The Borough of Bedford Local Access Forum (BOBLAF) comments on the Applications responses (REP1-055) to its Relevant Representation (RR-1252)

This document uses the Applicant's references in Table 14 of its response document.

East Park Energy
Figure 5-16b: Viewpoint 12 (Existing Winter View)

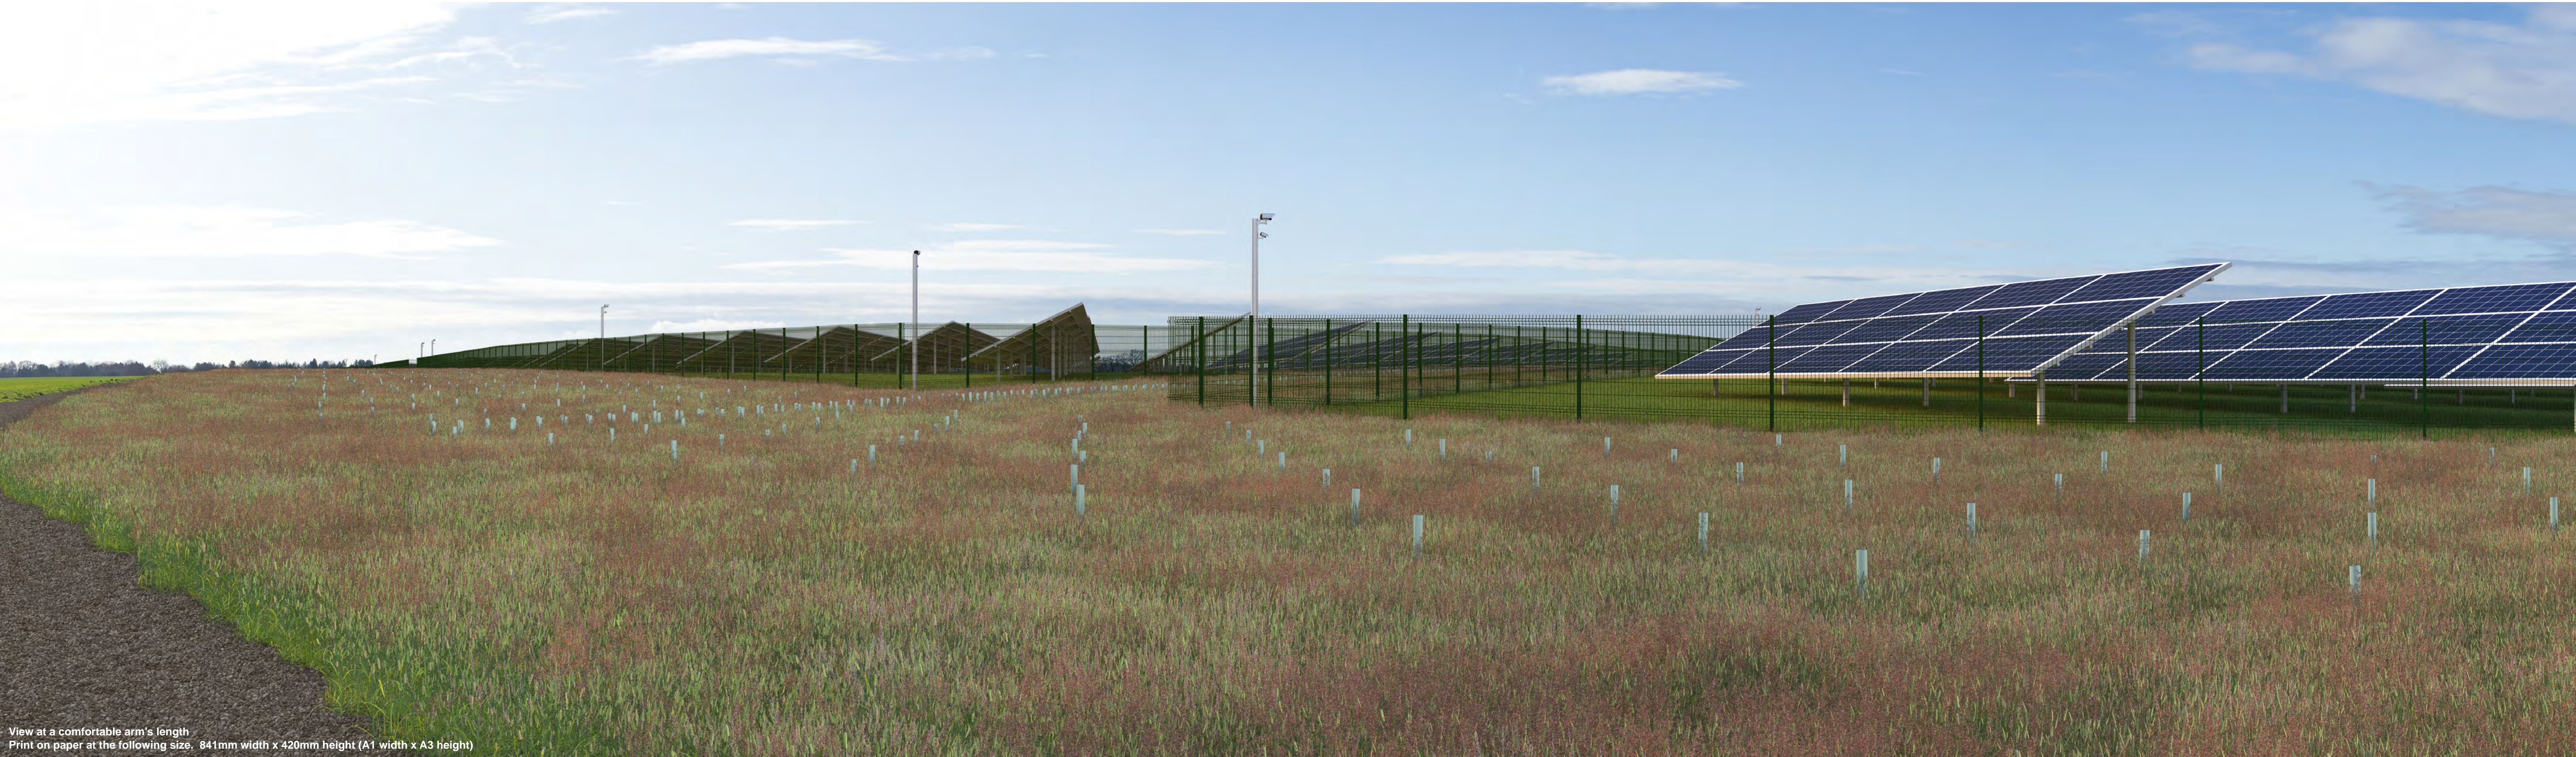
Whether the LVIA has or has not been prepared in accordance with guidance, we take issue with the conclusions that the year 10 visual impact at VP9 and VP12, which is rated as Moderate Adverse, can be viewed as Not Significant. 50% of the views from this Bridleway will be eliminated by the trees to be planted as screening. This is over a distance of about 1km. How can this be deemed insignificant?
